Section 96A of the Town & Country Planning Act 1990 (as amended)
Town and Country Planning (Development Management Procedure) (England) Order 2010 (as amended) - Article 9

Application for a Non-Material Amendment following planning permission AW/232/14/HH to increase width of garage by 500mm
1 Stanbrok Close, Aldwick, ,

Proposed Floor Plan      Scale:      1:20 @ A1

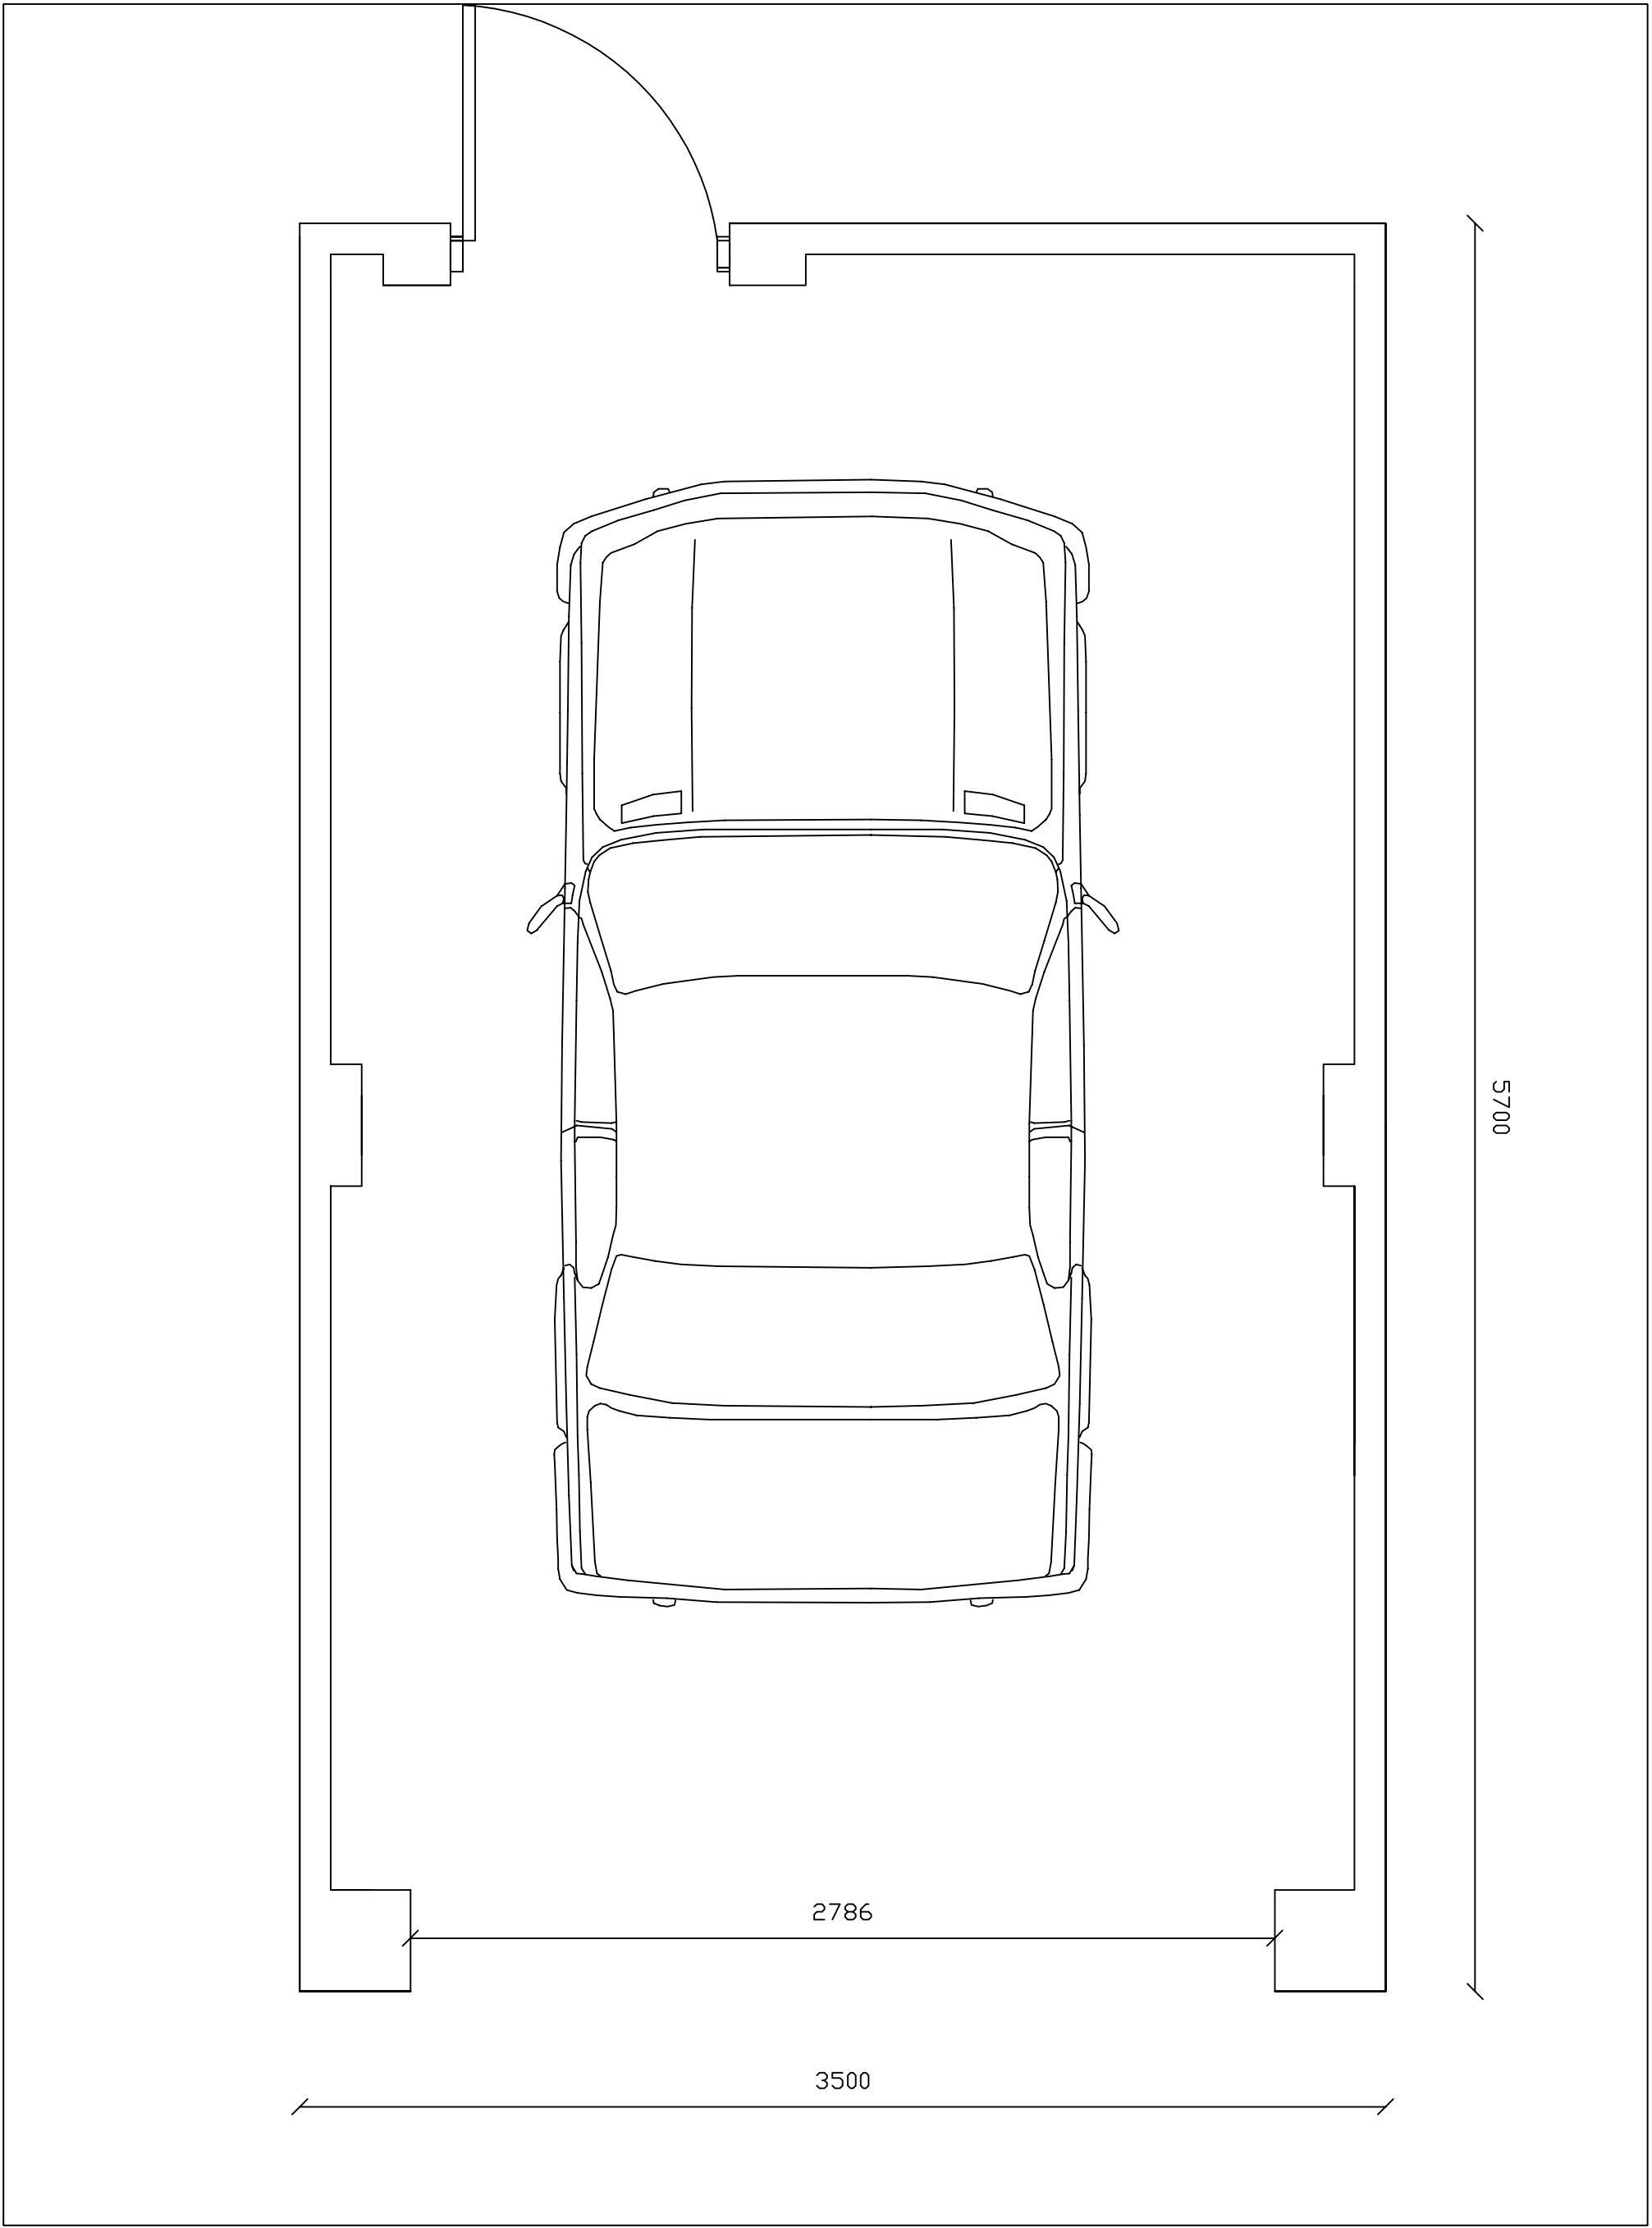
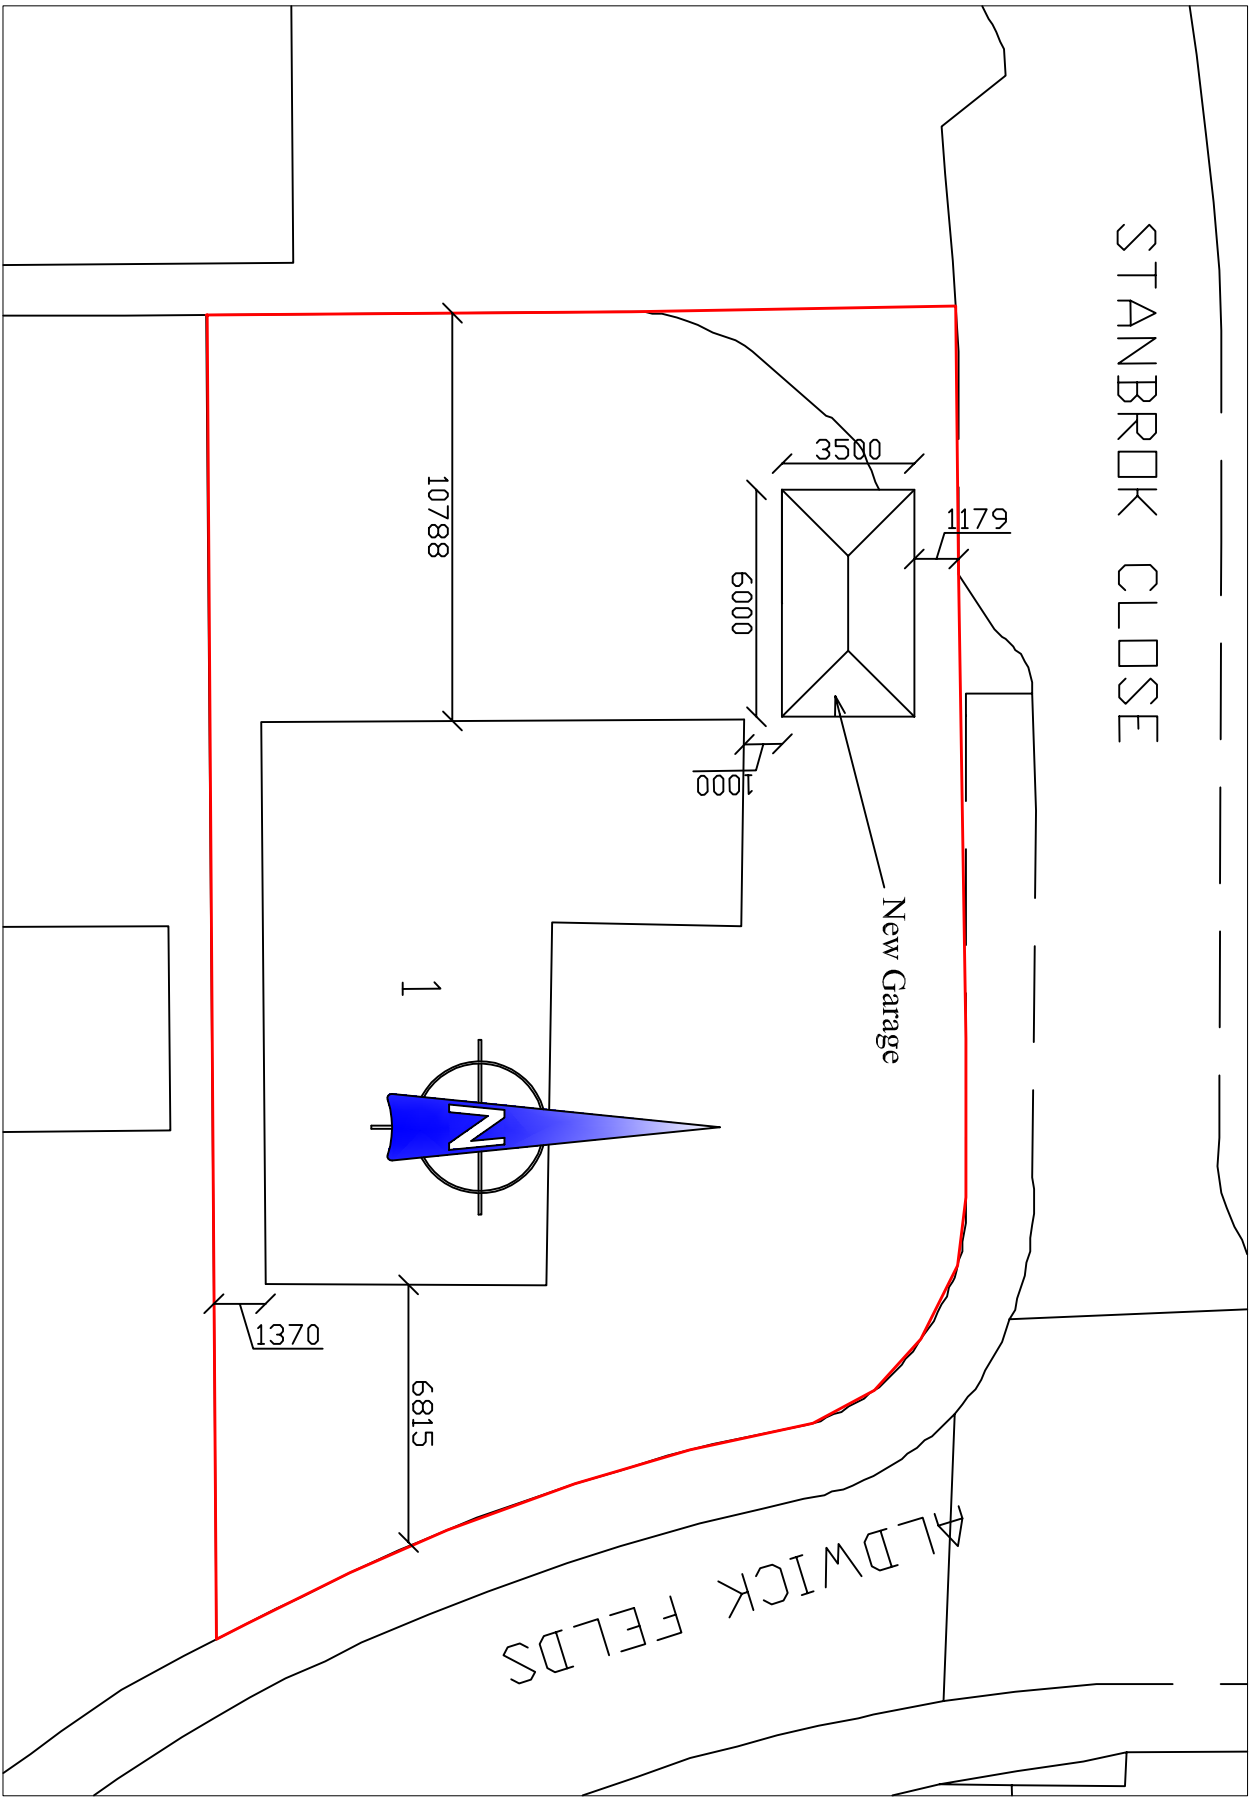
From the information submitted I am able to accept the increase of the garage width by 500mm from 3m to 3.5m. The submitted Drawing No TP-P-01 Rev 1 dt 22.1.15 now becomes the approved plan for AW/232/14/HH.
